## **Development Facilitation Team (DFT) – Review Comments**

**Project No: PR-2021-005394      Date: 06/26/2024      Agenda Item: #3 Zone Atlas Page: J-21**

**Request: VACATION OF PRIVATE EASEMENT TO BE FORMALIZED BY MINOR PRELIMINARY/FINAL PLAT FOR SINGLE LOT. REMOVING EXISTING PRIVATE ACCESS EASEMENT [1], SUBSEQUENT ACCESS EASEMENTS TO BE GRANTED CONCURRENTLY BY DOCUMENT. GRANT SANITARY SEWER EASEMENT 14 TO PRESERVE SERVICE ACCESS FOR ADJOINING LOT**

### **Application For: SD-2024-00109-PRELIMINARY/FINAL PLAT (DFT)**

**Boundary Survey,
 ALTA/NSPS Land Title Survey
 and
 Topographic Map
 for
 Lots B-1 and B-2-A
 Lands of Audio Clinic, Inc. and
 International Development
 City of Albuquerque
 Bernalillo County, New Mexico
 February 2023**

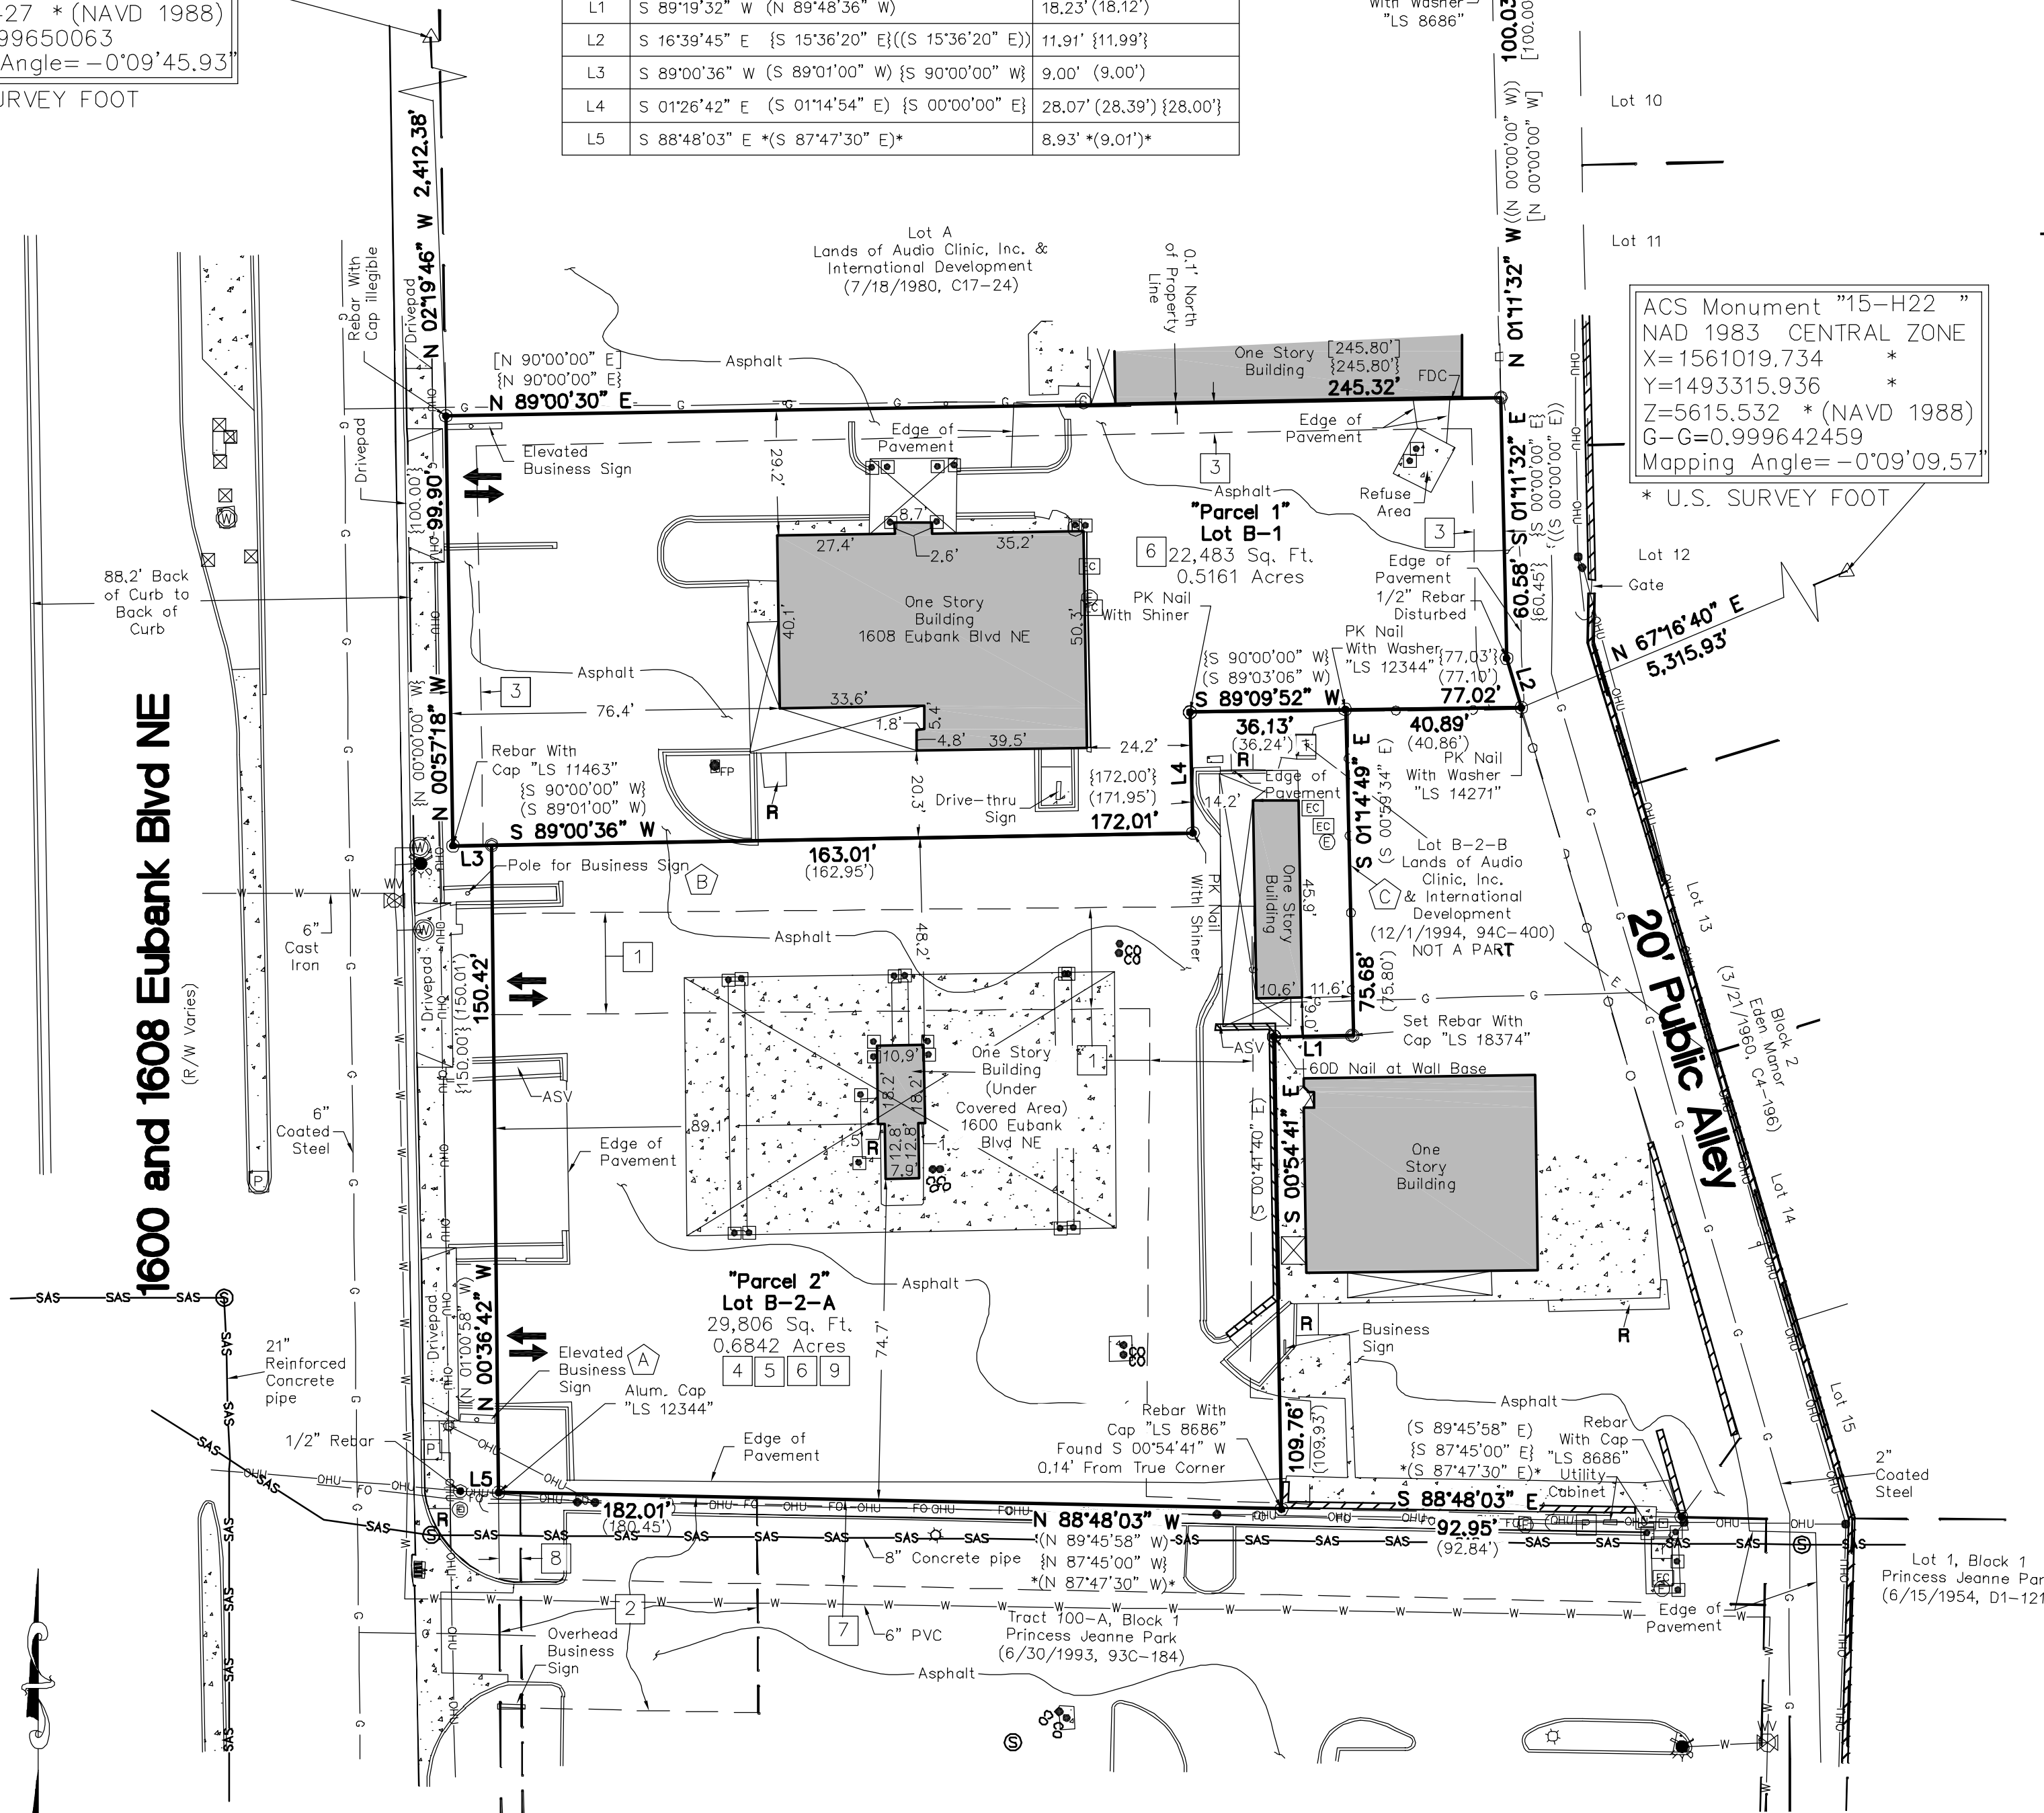
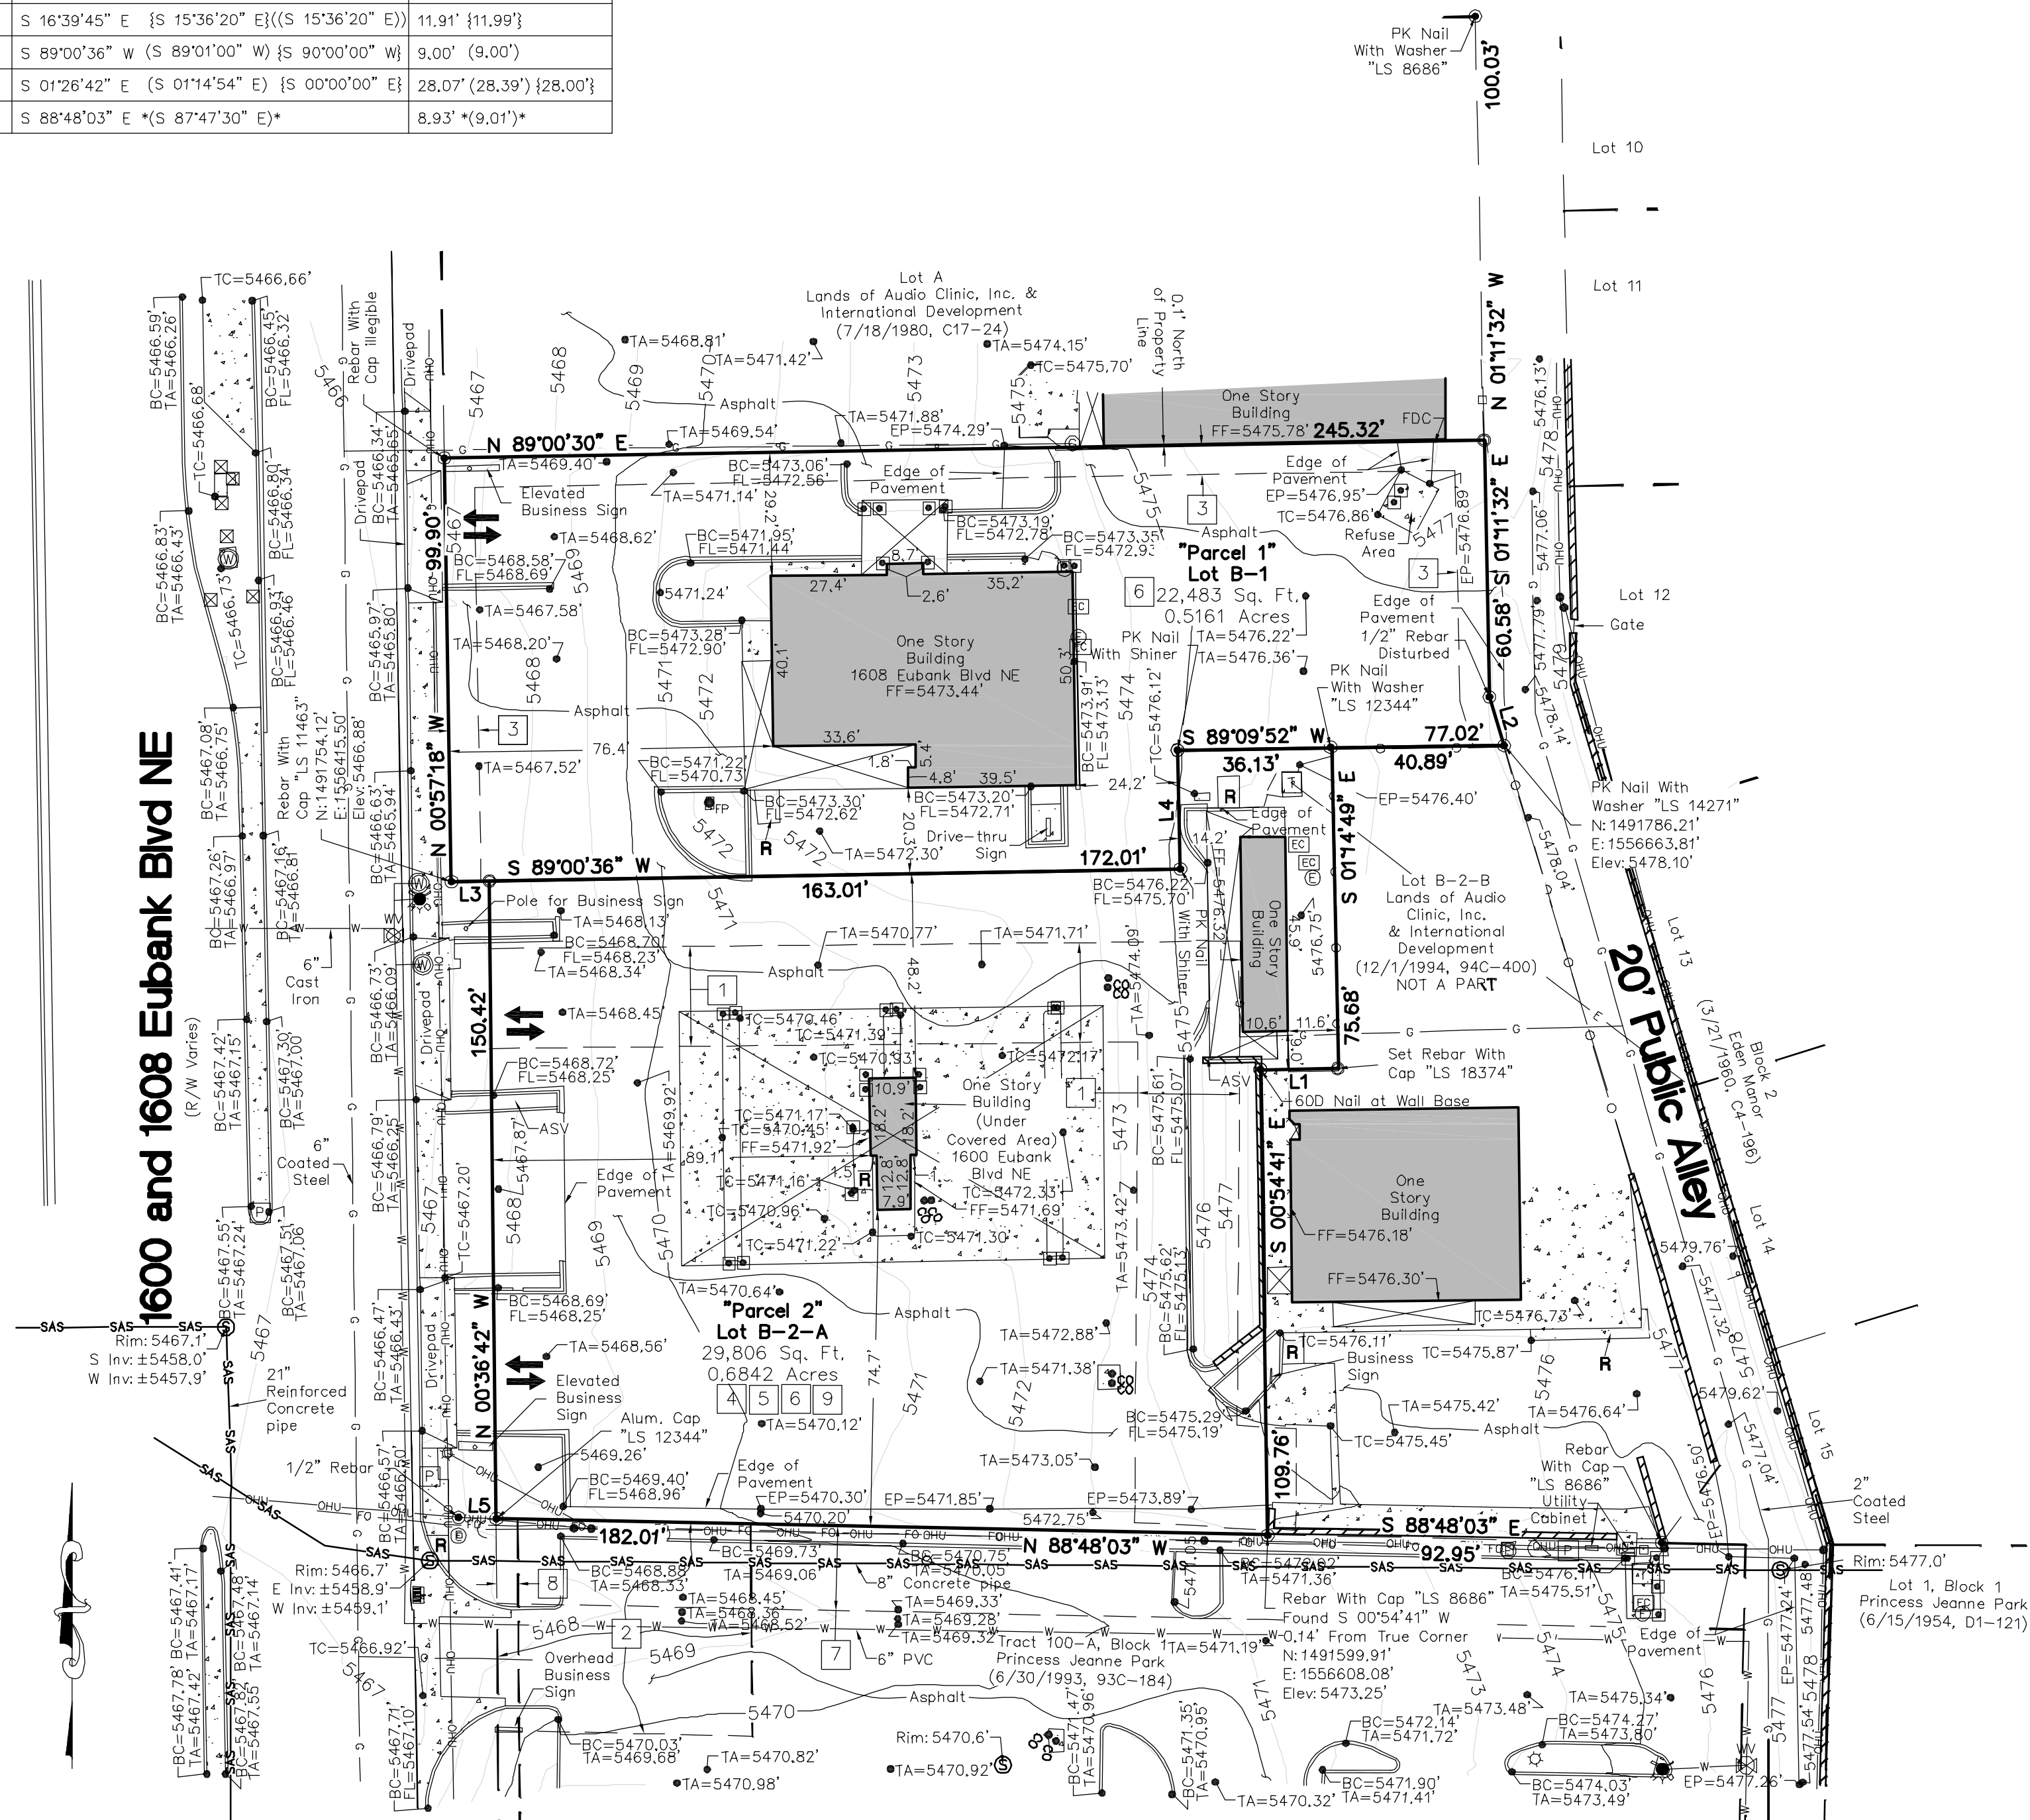
- Demonstrate compliance with Section 7 of the DPM, Table 7.2.29 and required improvements section from 5-4(N) of the IDO. In regards to the sidewalk width requirements and the accompanying landscape buffer.  
***\*Verification of standards per Transportation\****  
 Confirm measurement for the existing ROW and distance from curb to property line along street frontage.
  - Eubank Blvd is a regional principal arterial. Not in a Center or Corridor area. This street requires a 6-foot side walk and 5-6-foot landscape buffer.

The plat demonstrates that the area between the curb and the property line is 17.6 feet wide. Existing sidewalk is 6 feet wide. Therefore, an 11.6 feet wide landscape buffer will be available along the frontage of this property. The existing landscaping condition is not up to the standards per IDO section 5-6 Landscaping and Screening. Landscape buffers are not providing sufficient street trees along Eubank Blvd. Additionally, shrubs are required to screen any drive-through lanes visible from the street per 5-5(I)(2) of the IDO. Please clarify regarding the future landscaping plan for the landscape buffer along Eubank Boulevard per the items discussed above.

- Signature from the owner must be provided on the plat.
- The application number must be added to the Plat sheet.
- Planning staff defer to Transportation regarding the proposed easement vacation.

**It appears that this site is not up to the standards of the street tree requirements. This item must be addressed.** Please see the image from the site frontage below for your reference.
